Application No: M/71/20/HH
Site Address: 18 Sea Way Elmer Middleton-On-Sea PO22 6JY
Description of works: Construction of first floor dormer to provide enlarged bathroom and wardrobe/storage, construction of detached garage

Thank you for your internet representation made on 15th October 2020 which has been recorded as an objection with the comments as follows:

DRAWING TITLE
**PROPOSED DETACHED GARAGE
FLOOR PLAN AND ELEVATIONS**

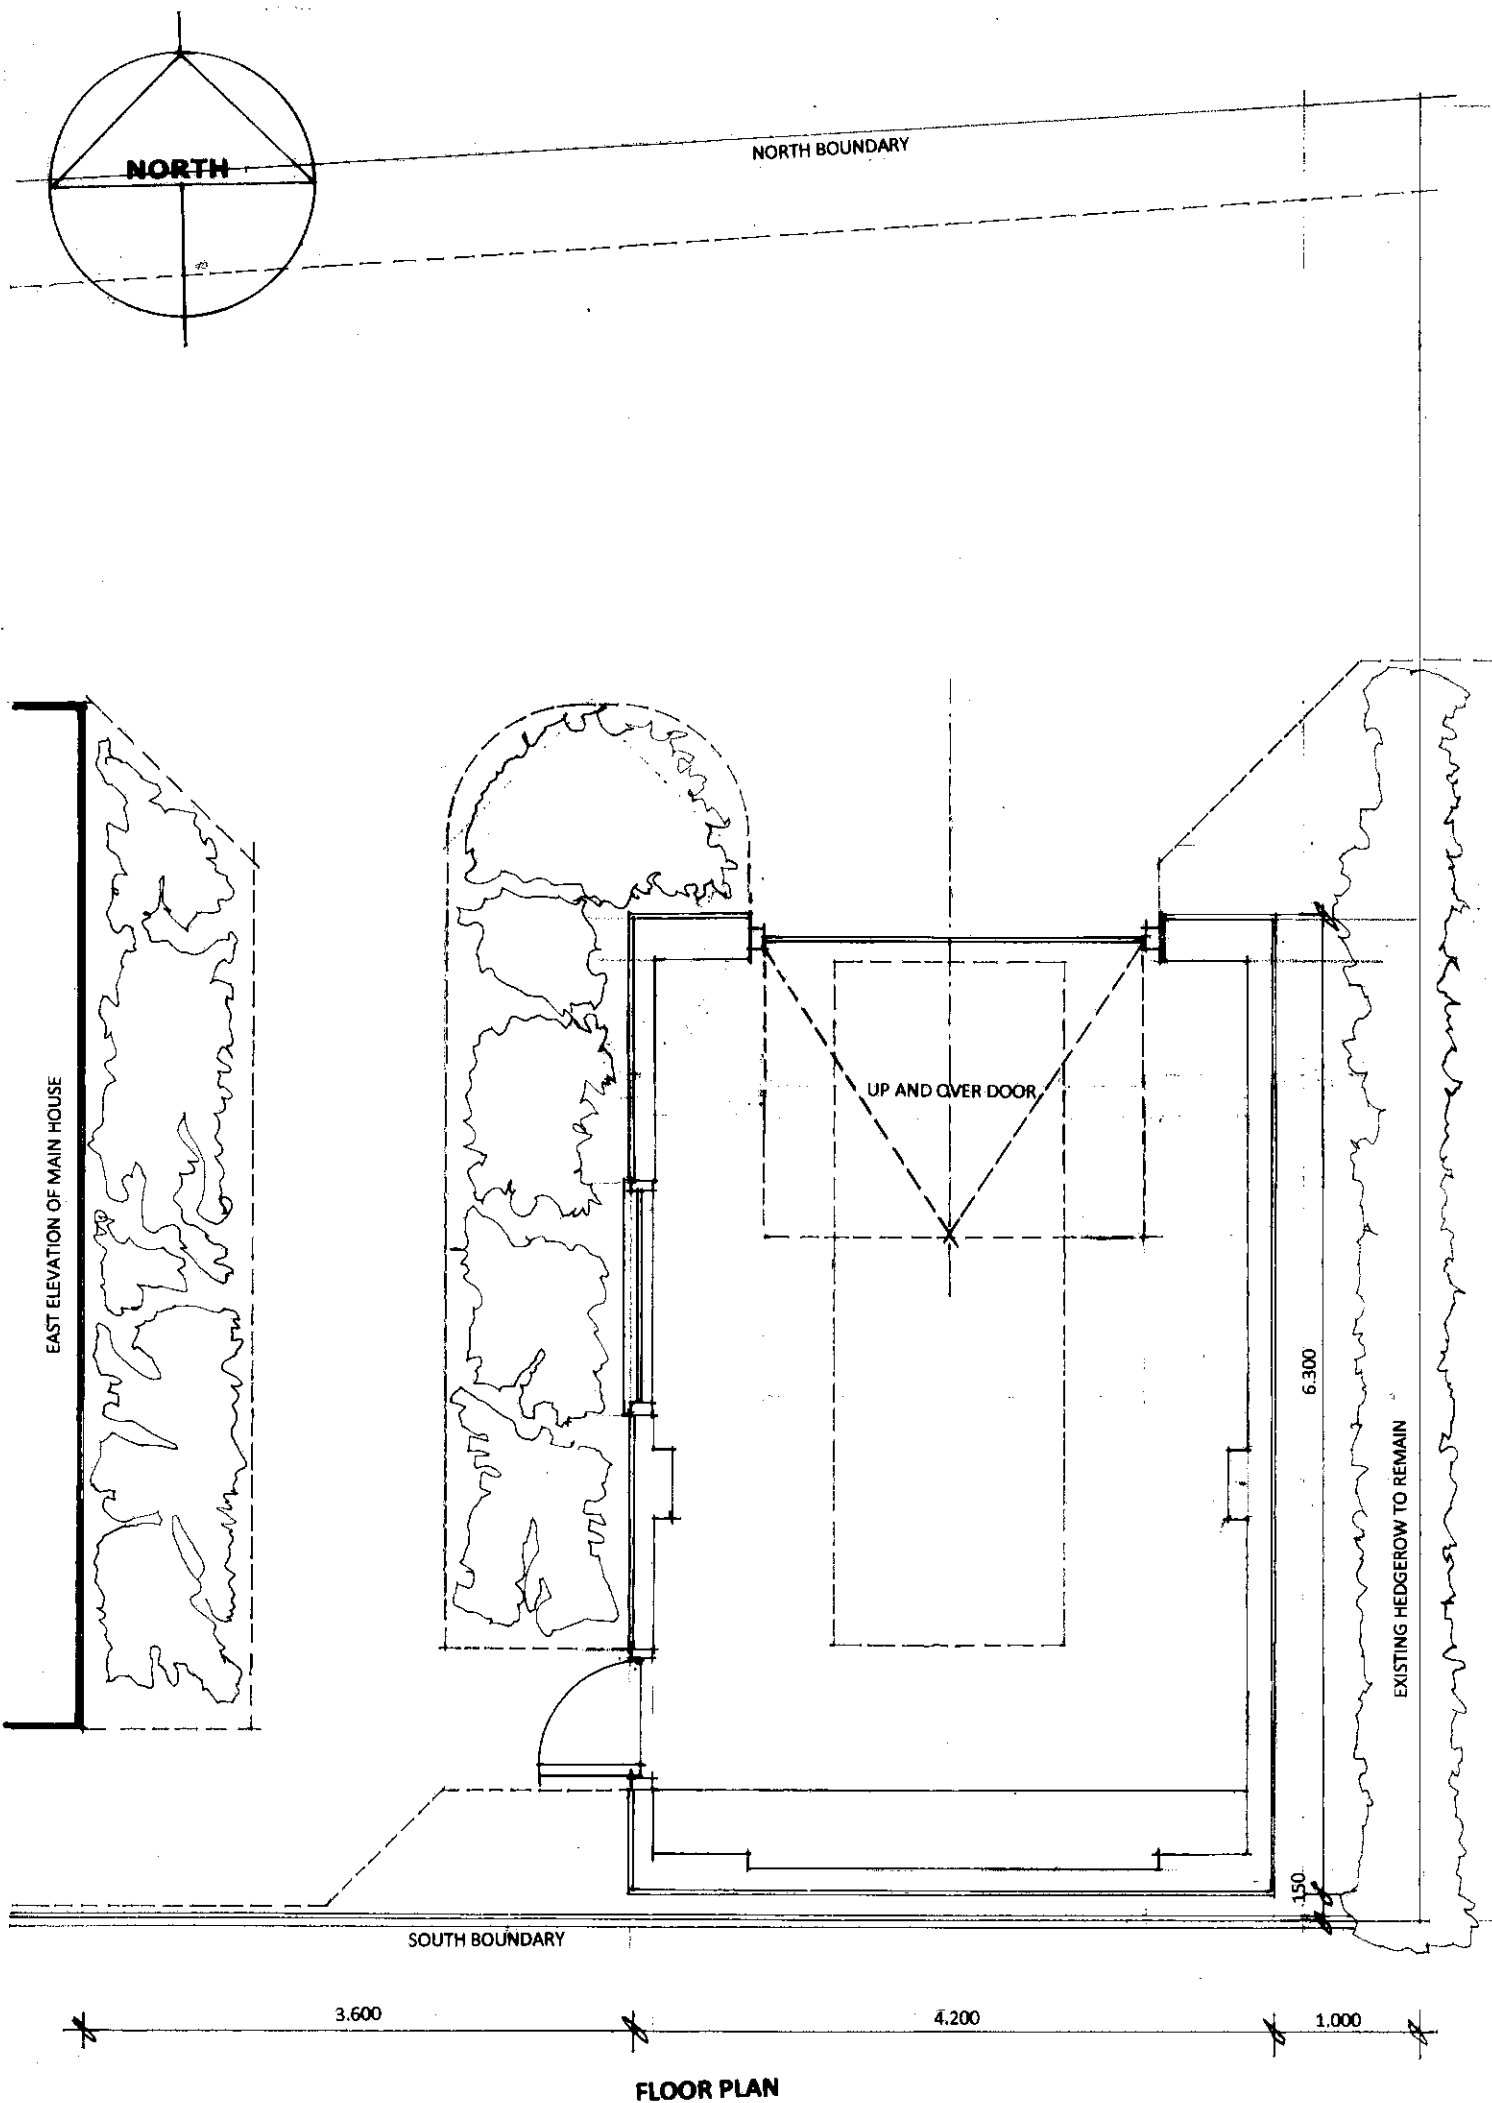
I wish to raise an objection - to the garage only, because of its location.
So far in front of the natural building line of the adjacent properties its design is simply out of keeping
Its close proximity to 16, spoiling the view from the front conservatory
Obtrusive pitched roof which no doubt will cause overshadowing problems, the section on drawing 11521.17 clearly shows how unacceptably high it is with the entire roof line above the existing boundary hedge.
I genuinely feel it to be an out of keeping overdevelopment of the small front garden area.
Surface water concerns. I have lived here 38 years and on many occasions each year have seen water laying on both 18 and 16.
They are the 2 lowest level plots in the vicinity.
I have gone to the lengths of reducing the ground to the front of 16, putting in terram and stone to help with the problem.
I have even put them in the verge adjacent to the drive entrance, as until I did it was semi permanently under water during the winter.

Removing such a significant area of natural ground drainage is of extreme concern giving consideration to the water table being only circa 900mm from ground level.
